From: Paul Cann
Sent: 24 April 2017 12:48
To: Planning.Responses
Subject: RE: Planning Consultation on: WA/26/17/HH

Engineers comments in respect to surface water drainage:

Registered: 24th April
2017
Site Address: Park View Avisford Park Road Walberton BN18 0AP
Grid Reference: 97520 06010

Description of Works: Single storey rear extension, conversion of garage to habitable space & replacement of existing clay roof tiles with slate.

Drawing.
Proposed Elevations

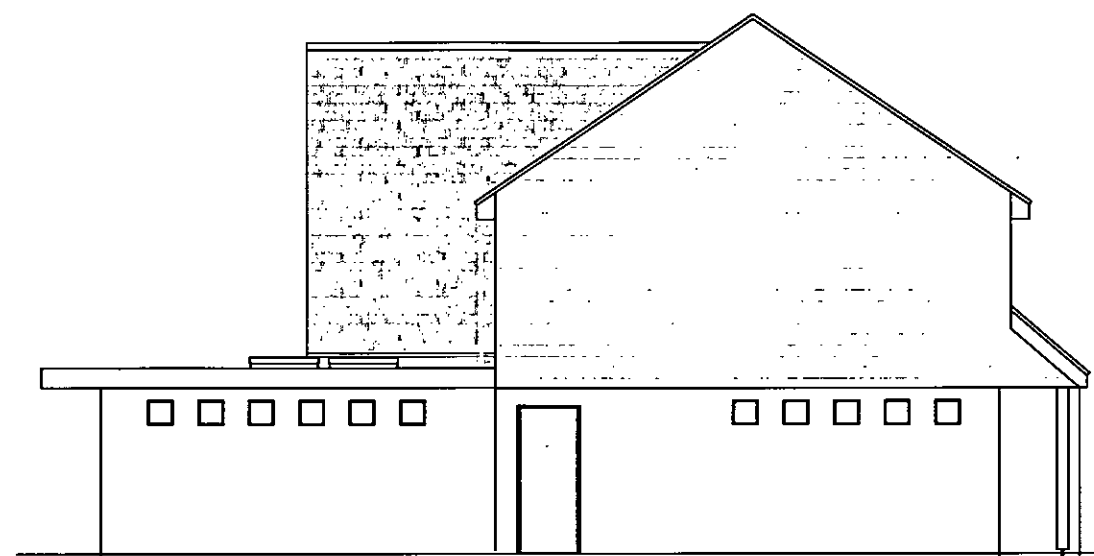
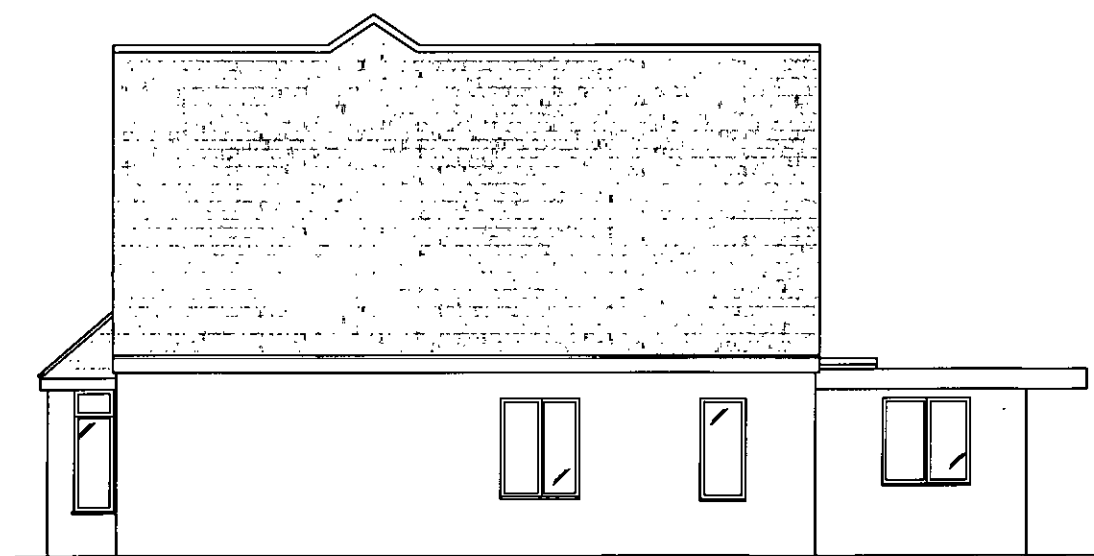
Infiltration to be investigated to drain new roof areas. No surface water to be discharged to the foul drainage system.

Infiltration rates for soakage structures are to be based on percolation tests undertaken in the winter period and at the location and depth of the proposed structures. The percolation tests must be carried out in accordance with BRE 365, CIRIA R156 or a similar approved method and cater for the 1 in 10 year storm between the invert of the entry pipe to the soakaway, and the base of the structure. It must also have provision to ensure that there is capacity in the system to contain below ground level the 1 in 100 year event plus 30% on stored volumes, as an allowance for climate change. Adequate freeboard must be provided between the base of the soakaway structure and the highest recorded annual groundwater level identified in that location.

Any SuDS or soakaway design must include adequate groundwater monitoring data to determine the highest winter groundwater table in support of the design. The applicant is advised to discuss the extent of groundwater monitoring with the Council's Engineers. Supplementary guidance notes are also enclosed for information.
